Address: 21, SOUTH BROOK GARDENS, MIRFIELD, WF14 8LS

Application number: 2026/CLD/91507/E	
What is the application for?:	Certificate of lawfulness for proposed change of use of residential dwelling (Us
Address of the site or building:	12, South Brook Gardens, Mirfield, WF14 8LS
Postcode:	WF14 8LS

| drawing     | PROPOSED PLANS & ELEVATIONS                                              |             |       |

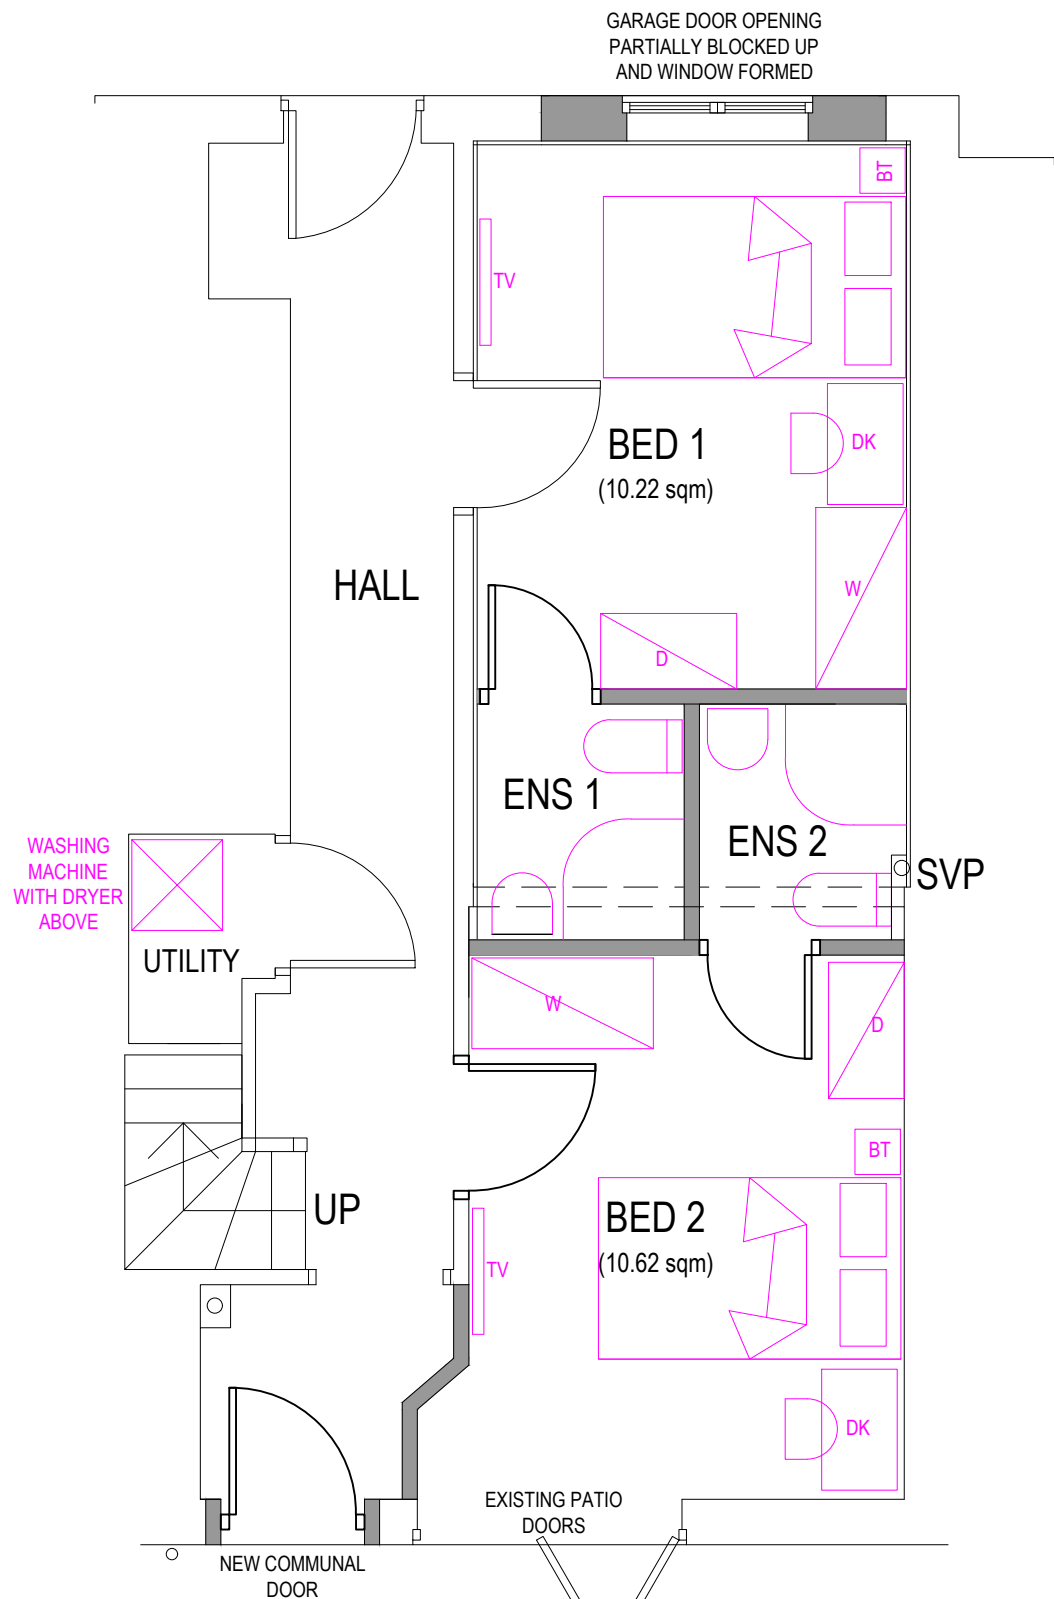
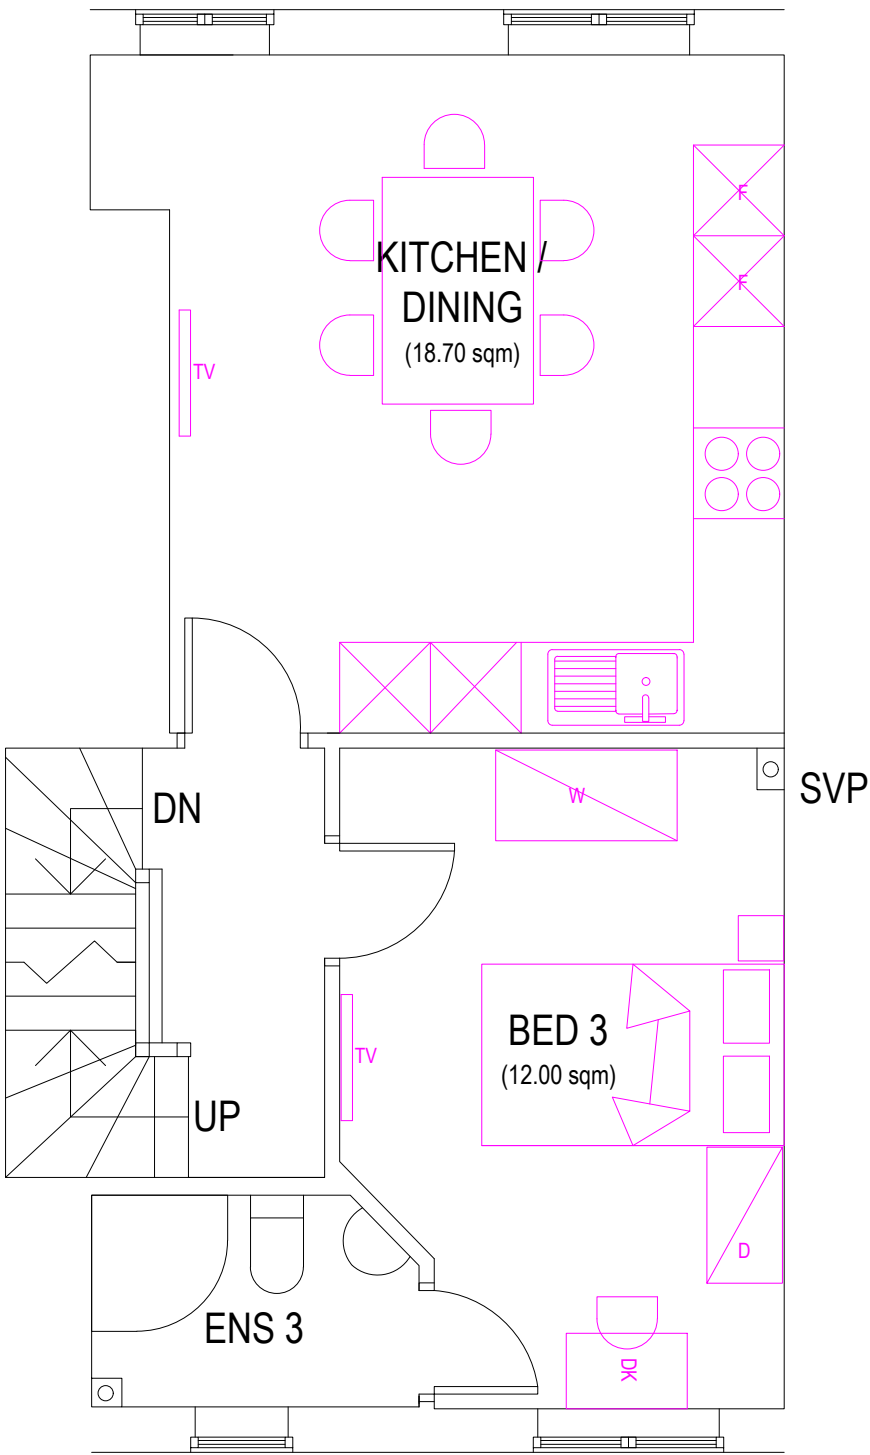
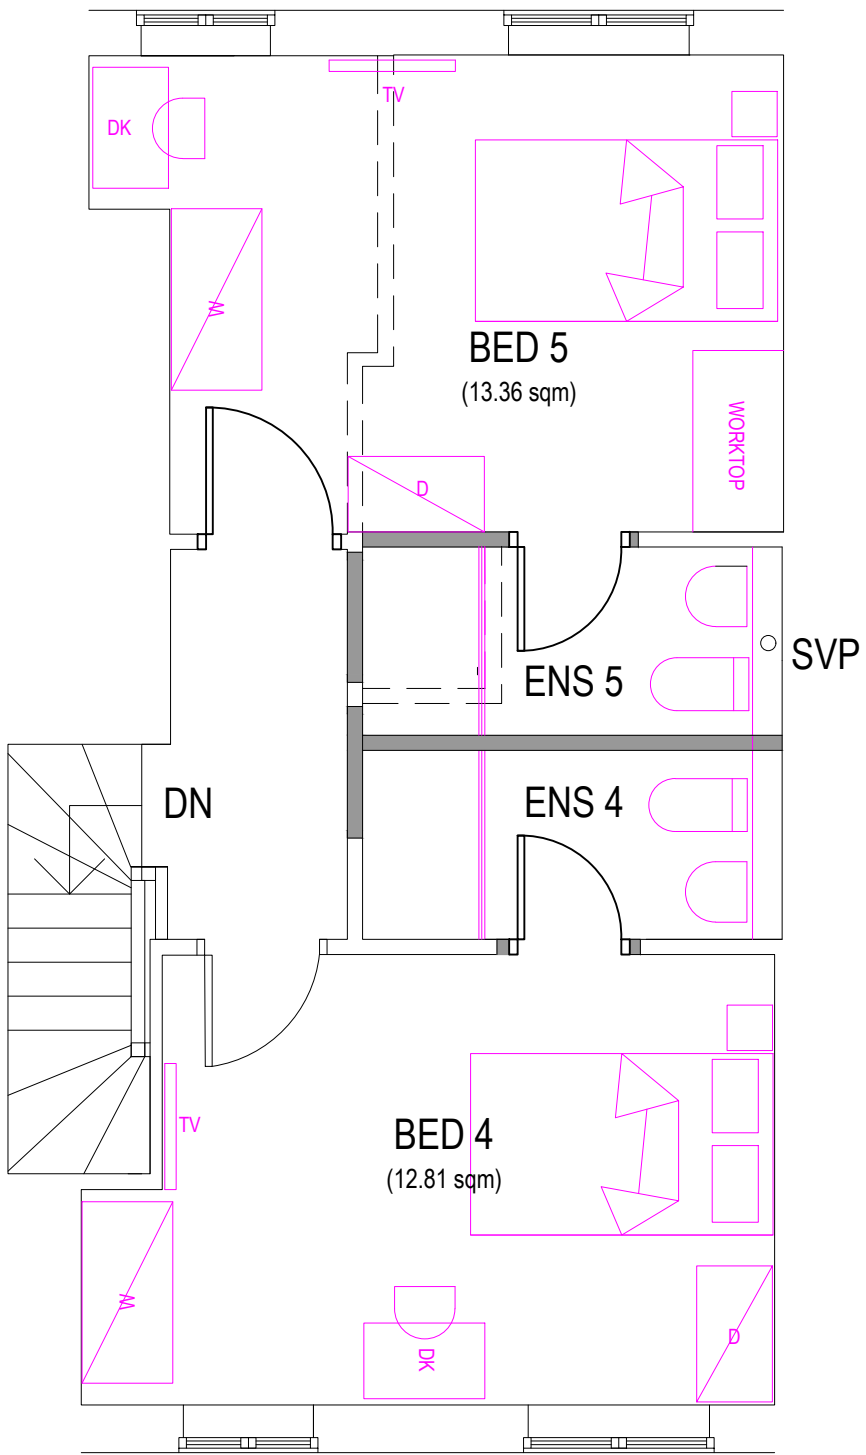
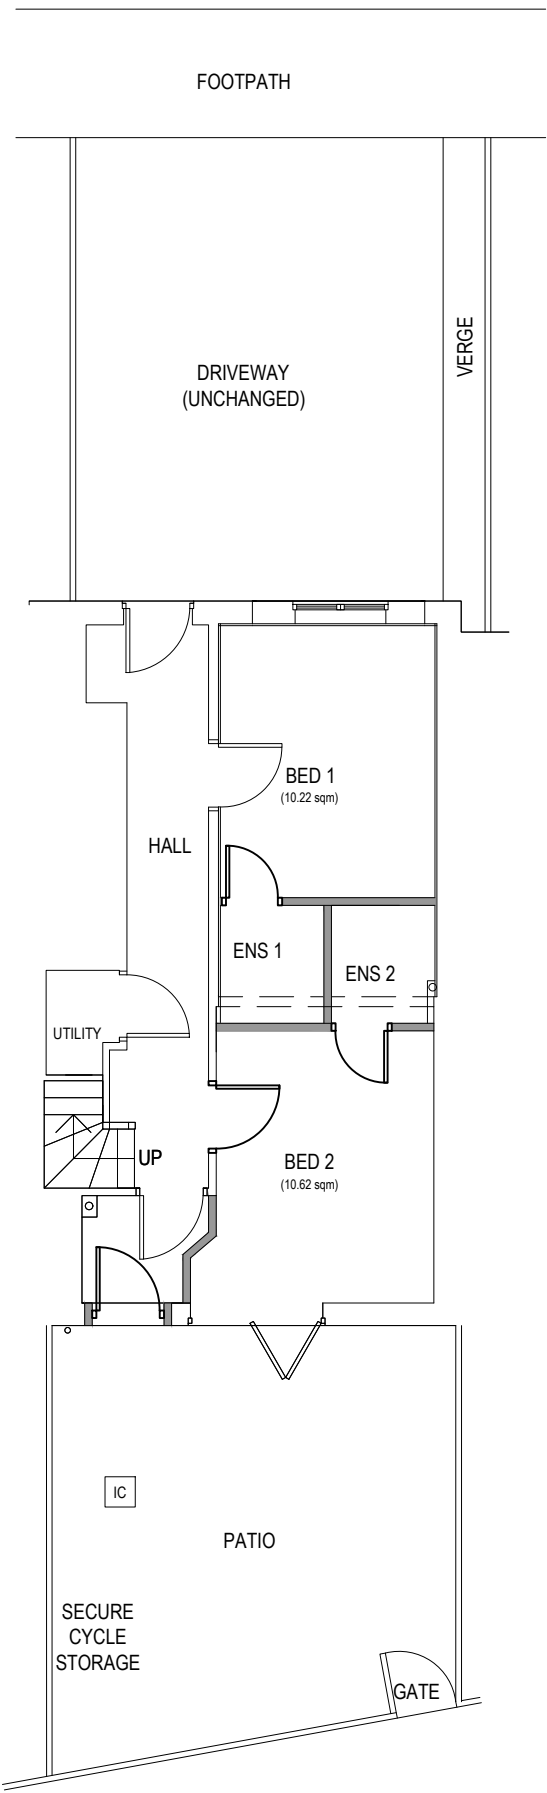
Type of comment: An objection	
Do you wish your comments to be published on the website anonymously?	No
I am writing to object to the issuance of a Lawful Development Certificate for application reference 2026/CLD/91507/E. The applicant's submitted floor plans indicate FIVE double bedrooms and 5 separate bathrooms, creating a layout optimized for a minimum of 10 occupants. As occupation by 7 or more unrelated individuals constitutes a Sui Generis use rather than Use Class C4, the development does not meet the criteria set out under Class L of the GPDO, and a full application for planning permission is required."
